OXFORDSHIRE COUNTY COUNCIL'S RESPONSE TO CONSULTATION ON THE FOLLOWING DEVELOPMENT PROPOSAL

Application no: 14/02025/HYBRID

Proposal: FULL - Phase 1 - 9,844 sq. warehouse; service yard for loading and unloading of HGVs and parking provision for 6 No cars, 4 No HGV lorries, 8 No trailers and a bicycle shelter; new vehicular access at northern end of site off Chilgrove Drive; improved visibility splays onto Camp Road and new landscaping treatment around the boundary of the site; OUTLINE - Phase 2 - 9,137 sq.m. manufacturing and storage facility; 3,000 sq.m. two storey office and training school; new vehicular parking area incorporating car parking, motorcycle spaces and a bicycle shelter and new vehicular access onto Camp Road

ANNEX 1
OFFICER ADVICE

Figure: **4**

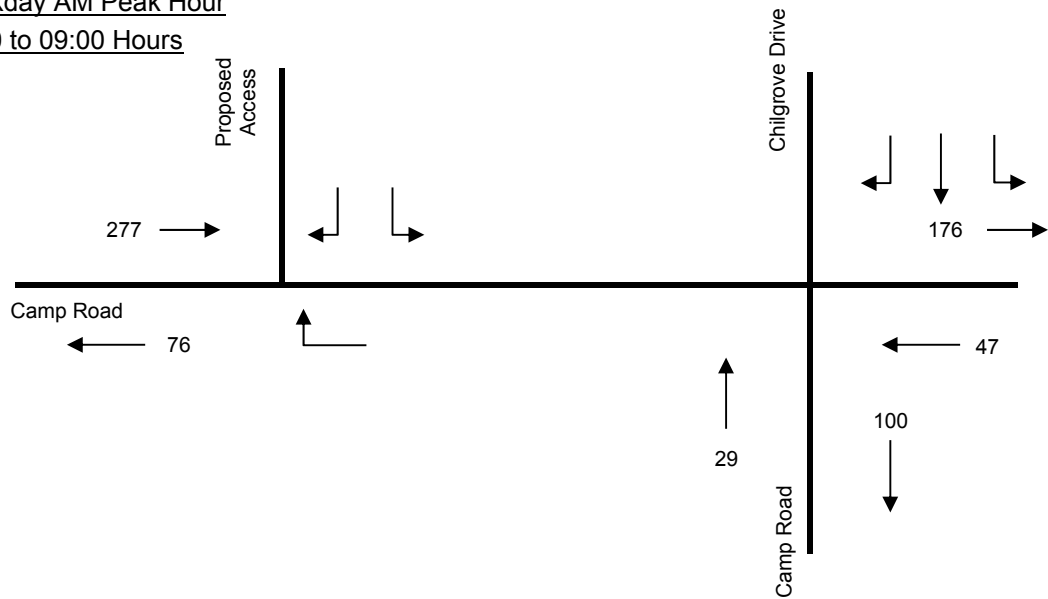
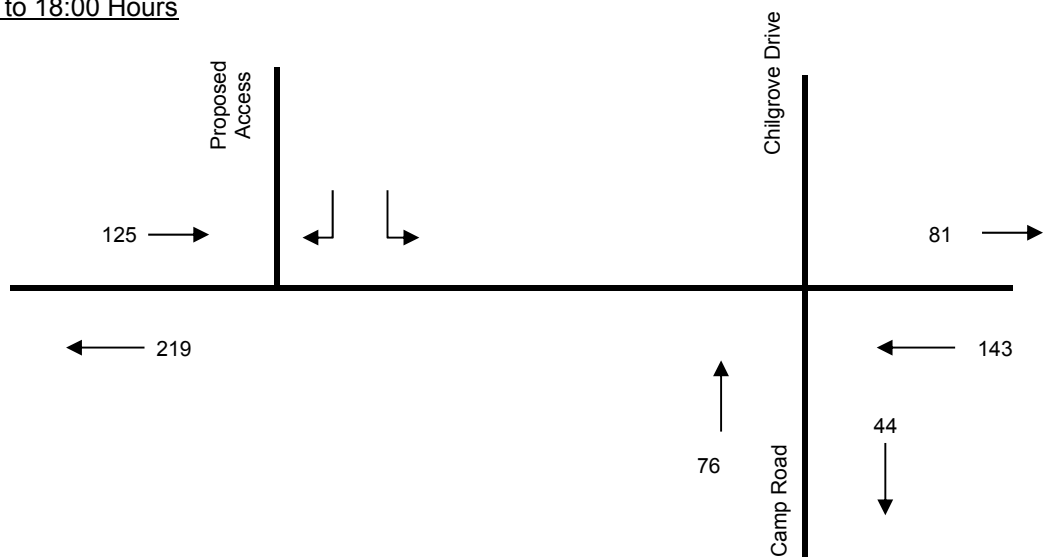
In para 5.6.3 the Transport Assessment refers to taking this development into account. However, it is not clear how this has been undertaken since that traffic flow data referred to is 2013 survey data and not Heyford Park committed traffic flows. Clearly some allowance has been made as this is presented in Figure 4 of the TA. However, the source of the traffic flows in Figure 4 is not given and their suitability cannot be reviewed.
